RE: Huntlee Mod9 Response to Submissions

I write to you on behalf of Huntlee Pty Ltd in regard to the S4.55 2 Modification Application (MOD 9) to Project Approval MP10_0137.

Table 1 Supplementary Response to submissions

20406-1 TO 3000 (MOD9) - PUBLIC EMBELLISHMENTS

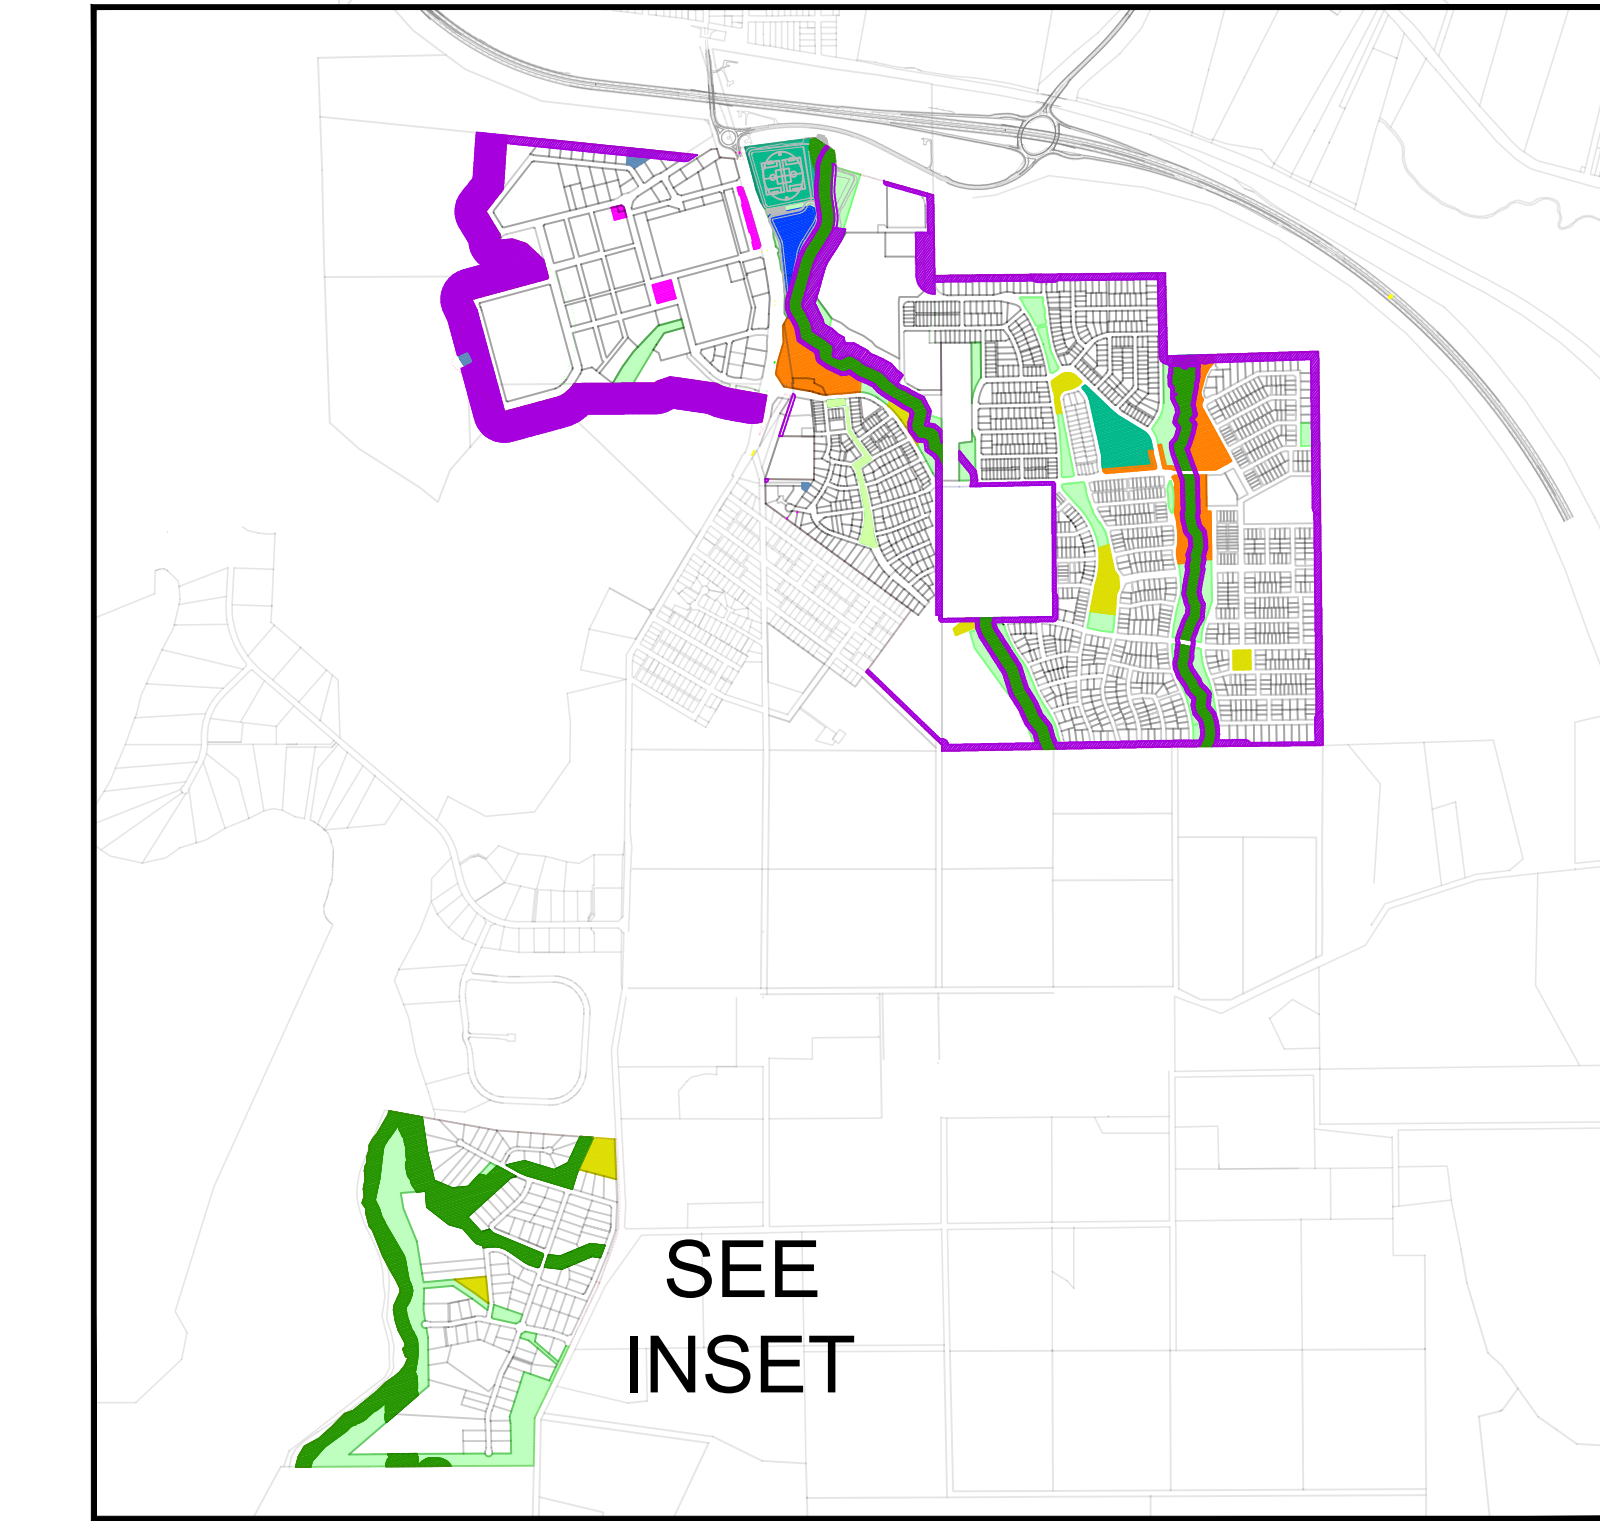
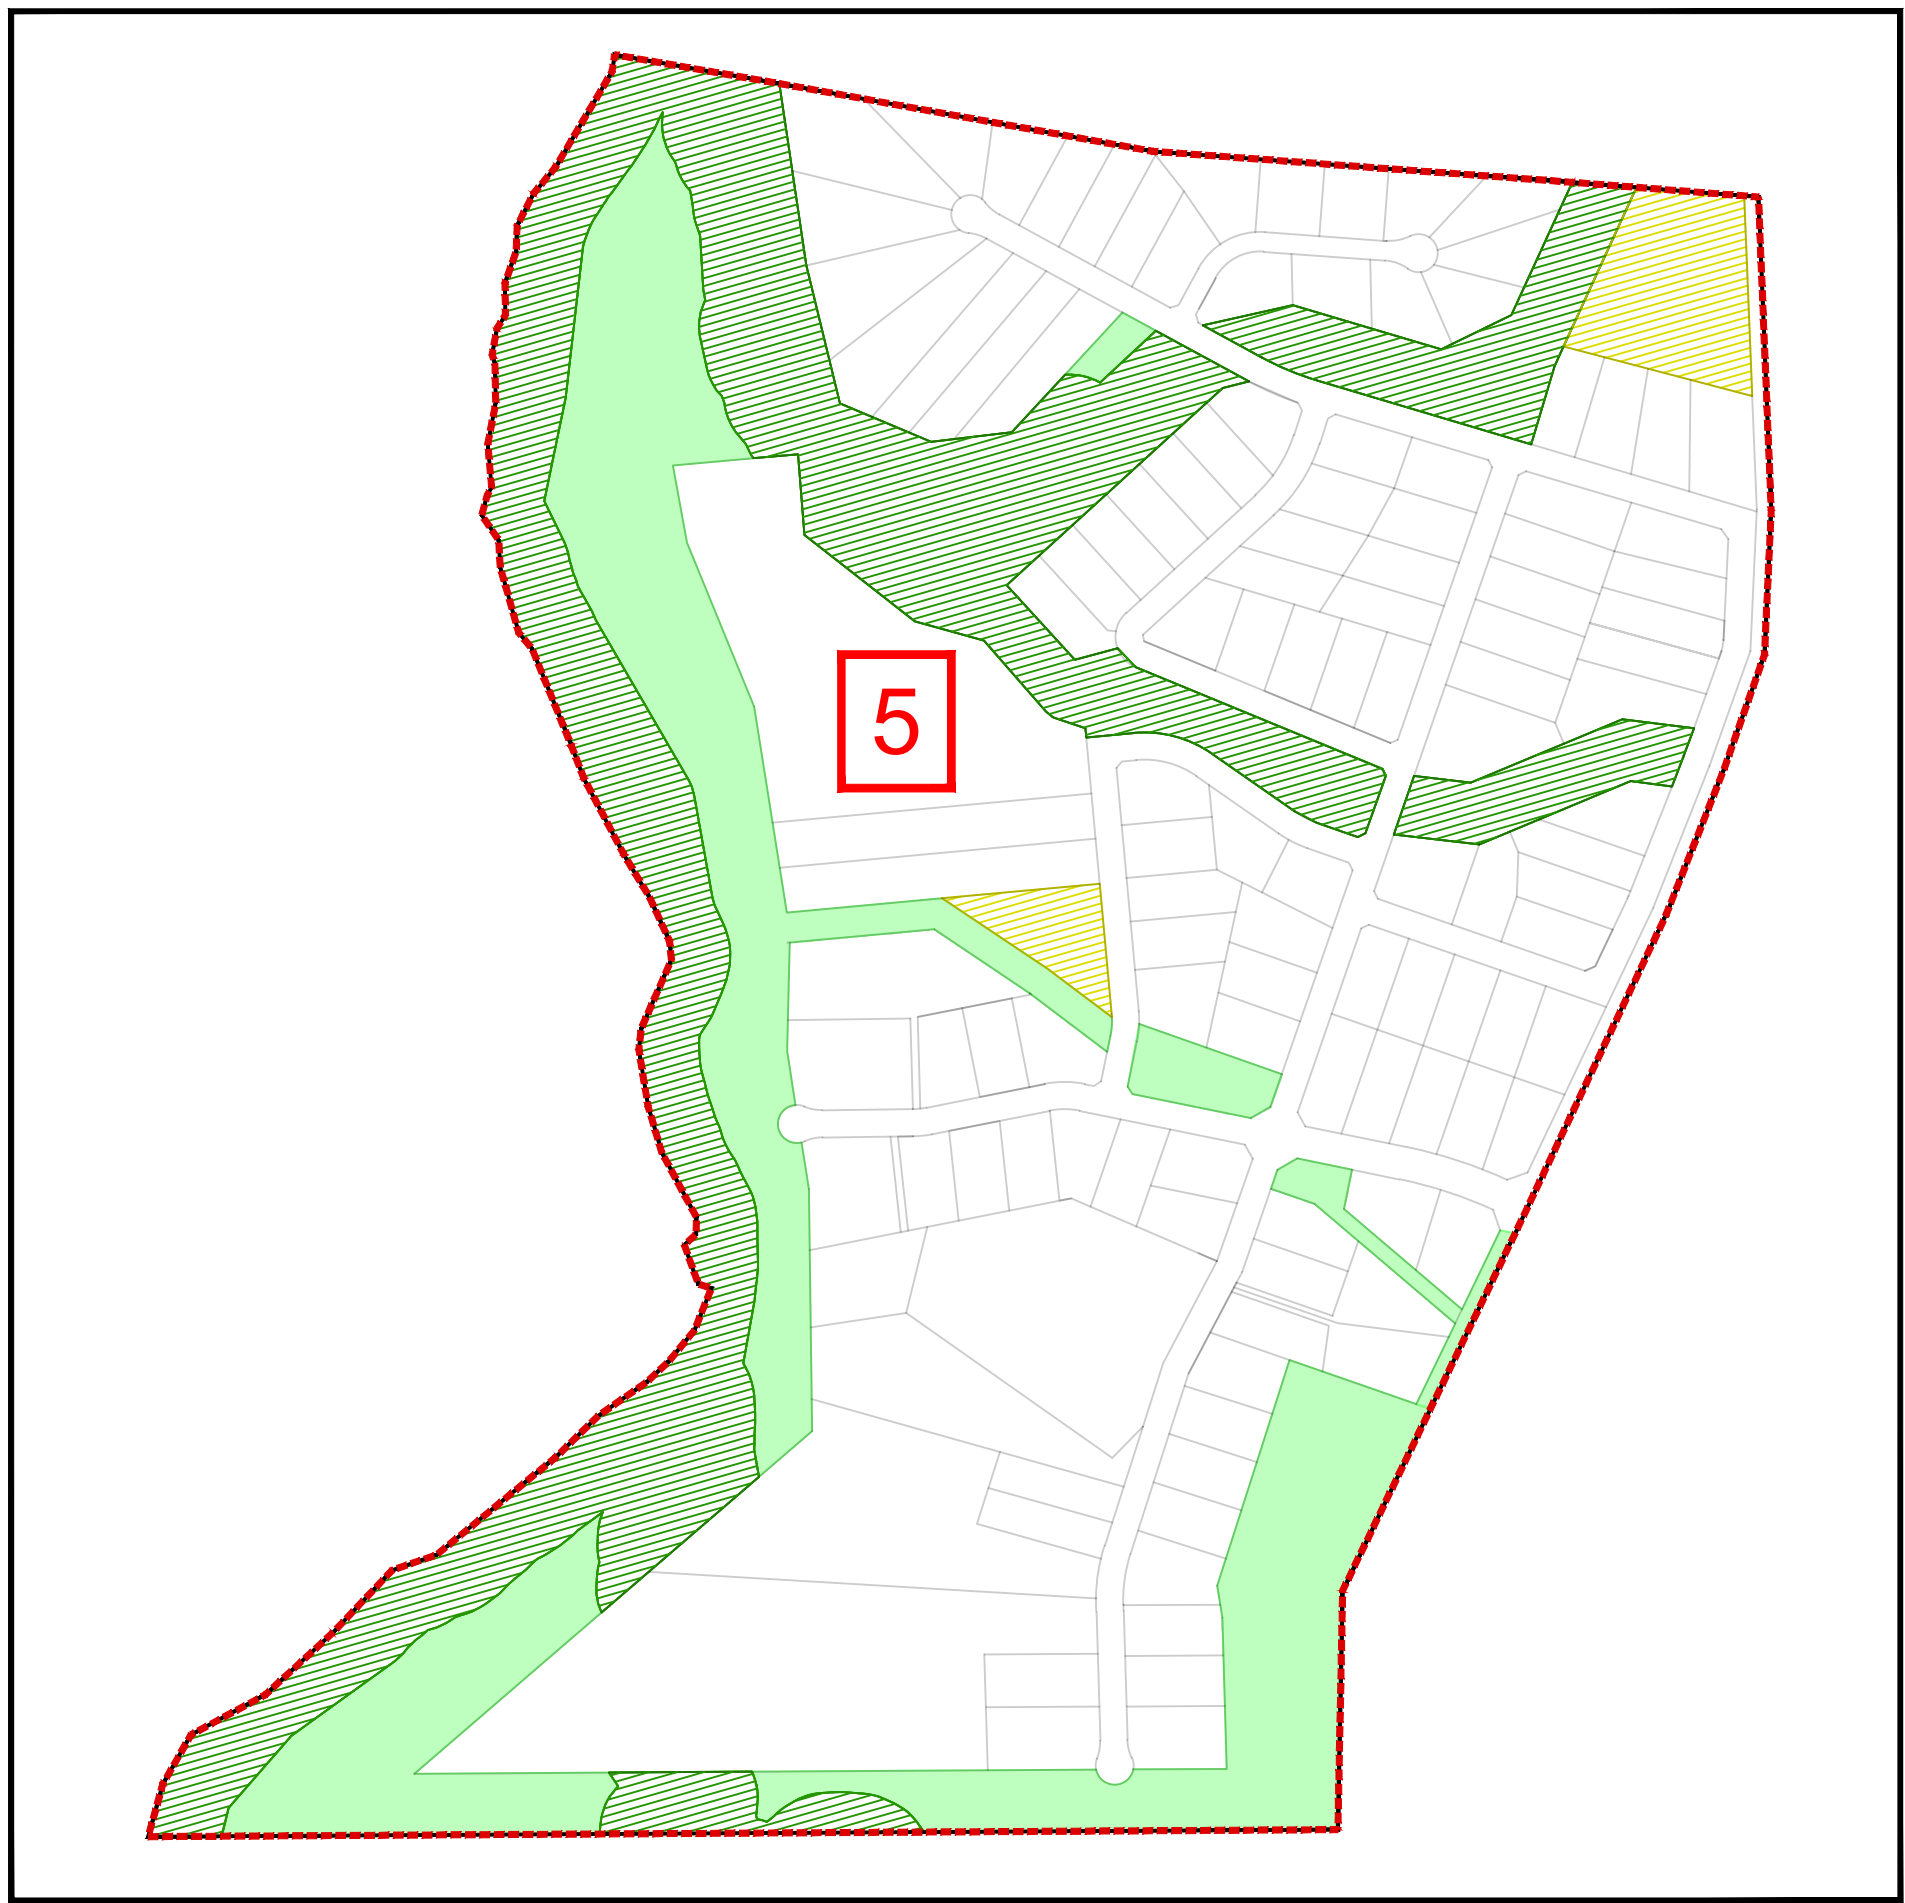
4. Open Space Provision • Provide breakdown of open space calculation • Demonstrate how the open space complies with the Council's open space requirements	• An updated Open Space Plan with updated calculation has been prepared and submitted at Attachment B. • The total envisaged dwelling number of 2345 in Stage 1 will result in an estimated population of 6,097 people based on the average 2.6 persons per household in Cessnock LGA. Based on Council's open space standards, the minimum provision of total recreation parks and sportsgrounds will be 7.92ha and 9.14ha respectively. The total provision of 84.54ha open space in Huntlee Stage 1, including 8.28ha of district park and 4.67ha of local park, is well above the council required open space rates. A final VPA in consultation with Council will reflect the final open space changes.

TITLE : FIGURE 2: PROJECT AREA WITH AHIMS

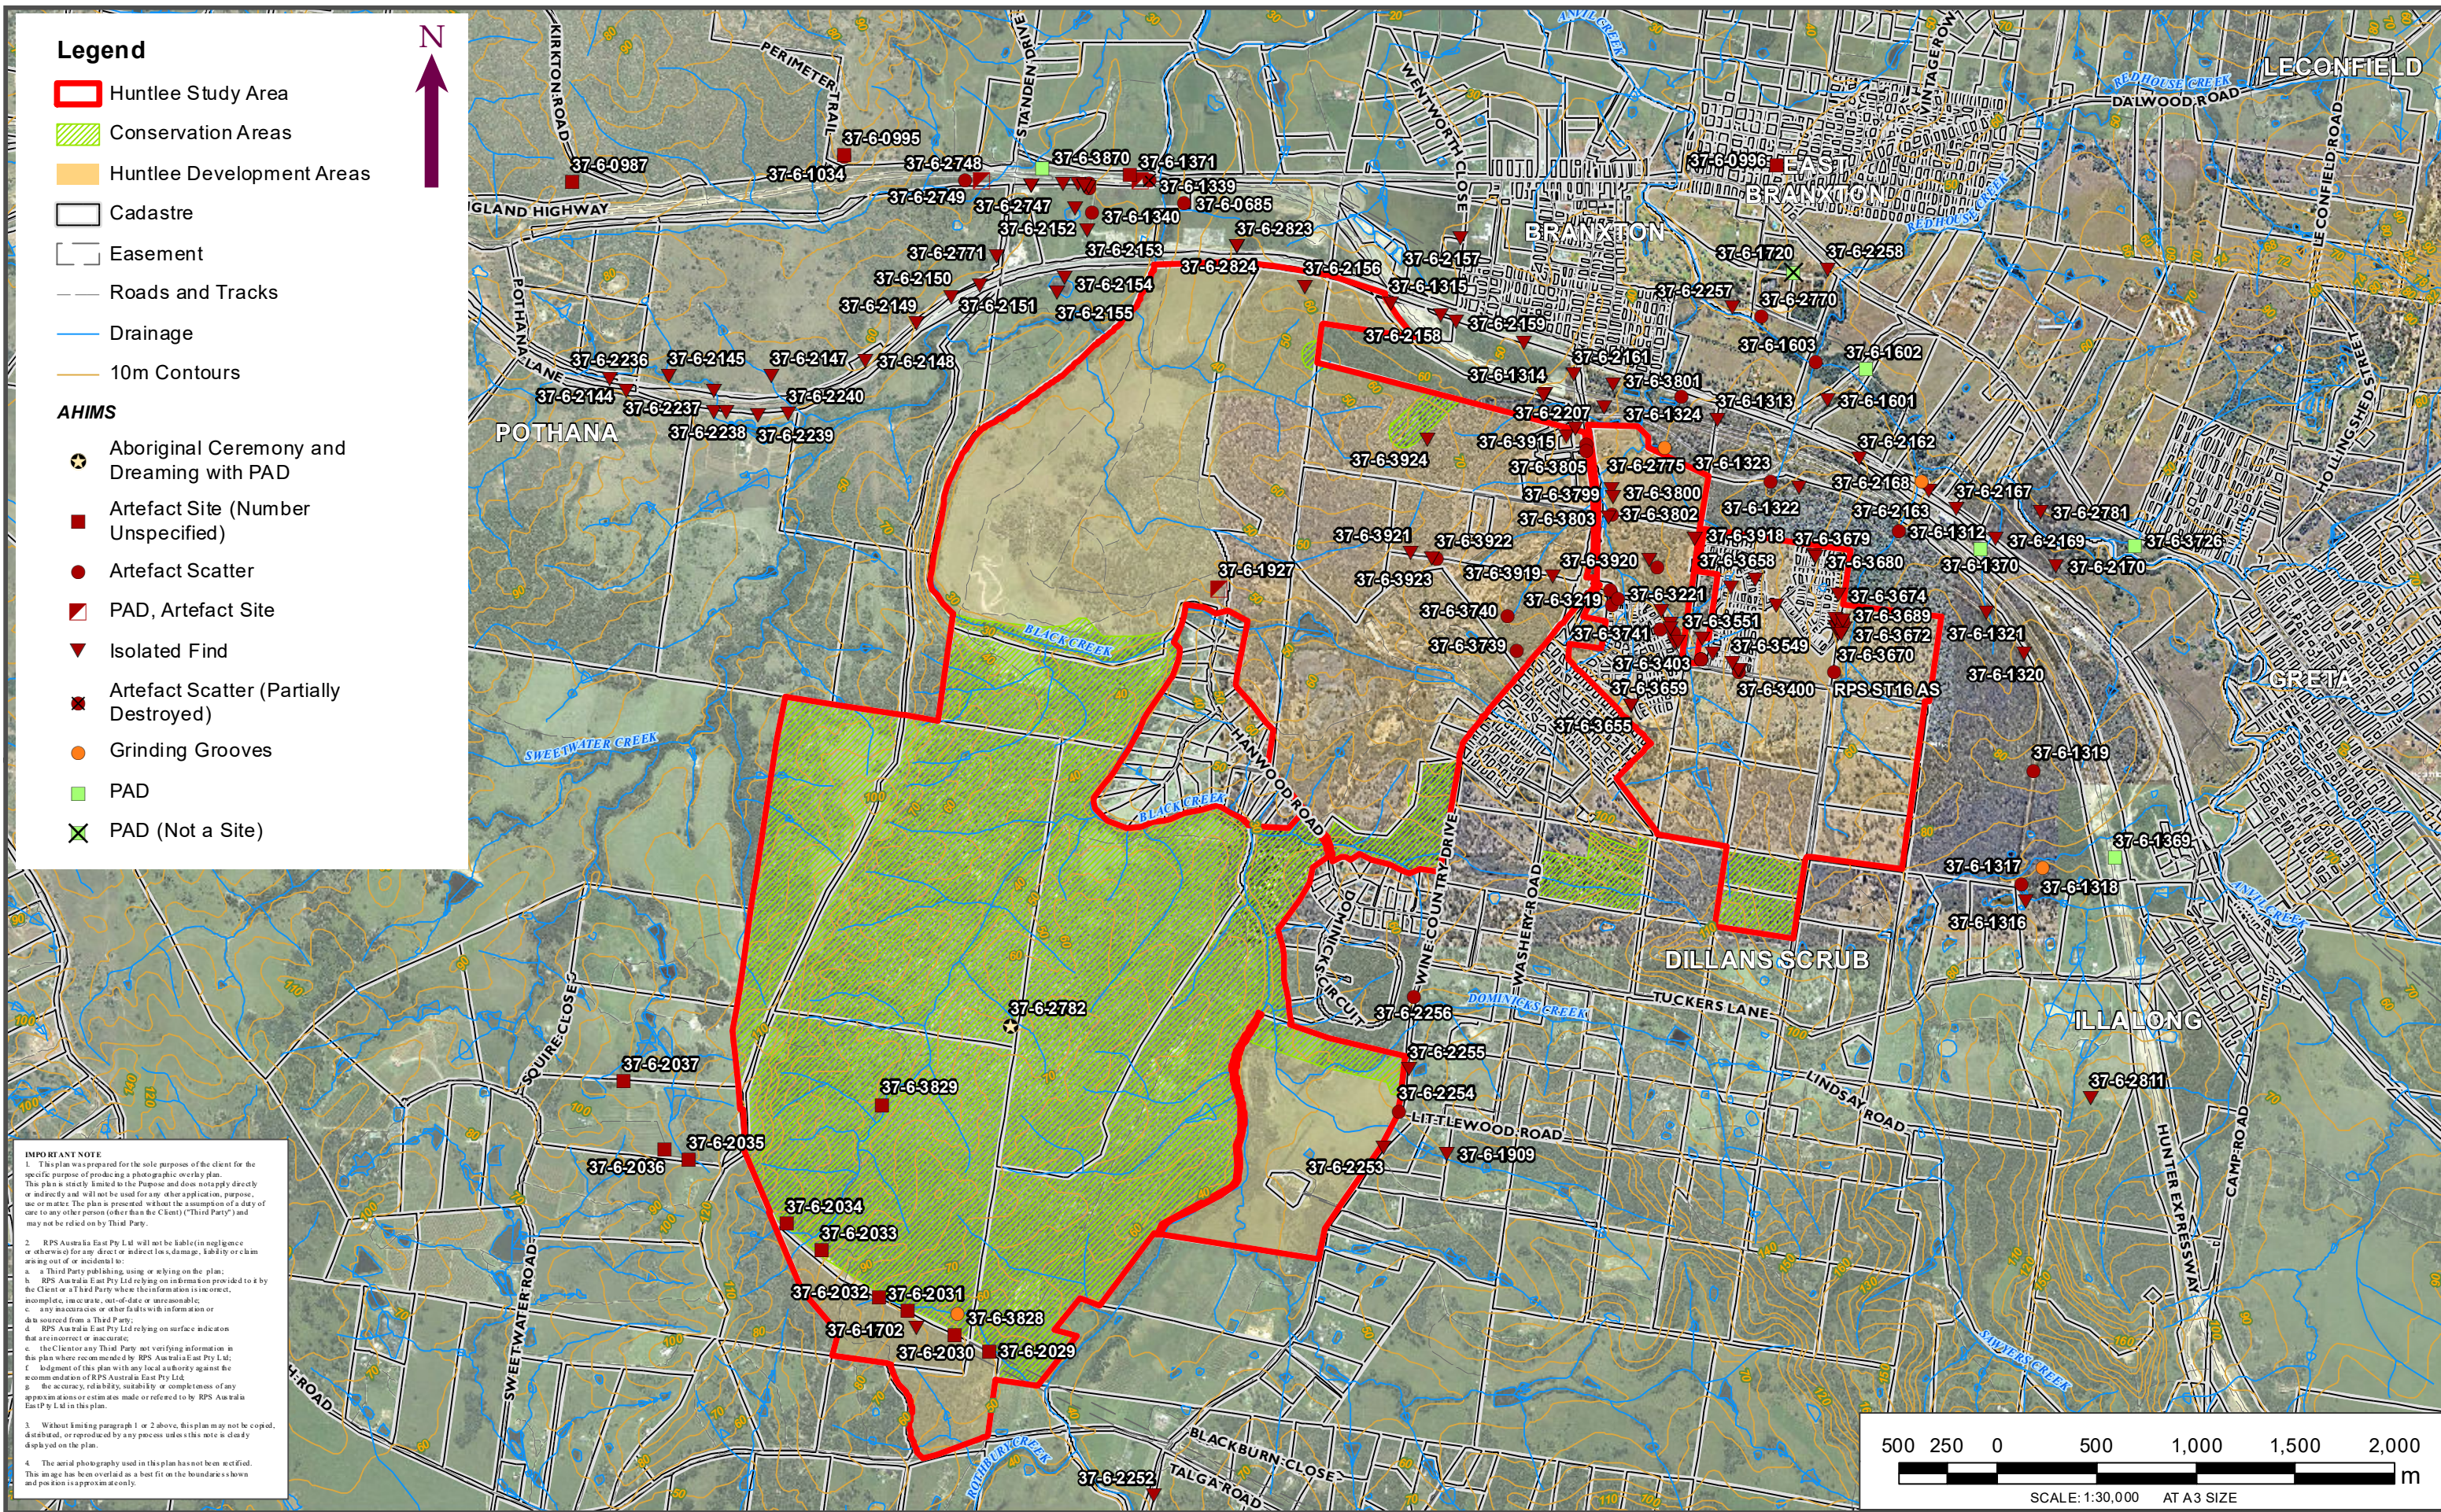
Aboriginal cultural heritage - The Aboriginal Cultural Heritage Management Plan (2015) should be updated to show the location and site status (including those previously located in TC1) of all registered Aboriginal Sites with AHIMS site numbers within the Huntlee Stage 1 (as amended) Residential Development Boundary. - The Aboriginal cultural heritage constraints and obligations identified for Mod 9 should be integrated into Aboriginal Cultural Heritage Management Plan (2015) prior to the commencement of further works.	An updated Aboriginal Cultural Heritage Management Plan (2019) has been prepared to include the location, site status of registered Aboriginal Sites, constraints and obligations identified for Mod 9 (refer to Attachment F).
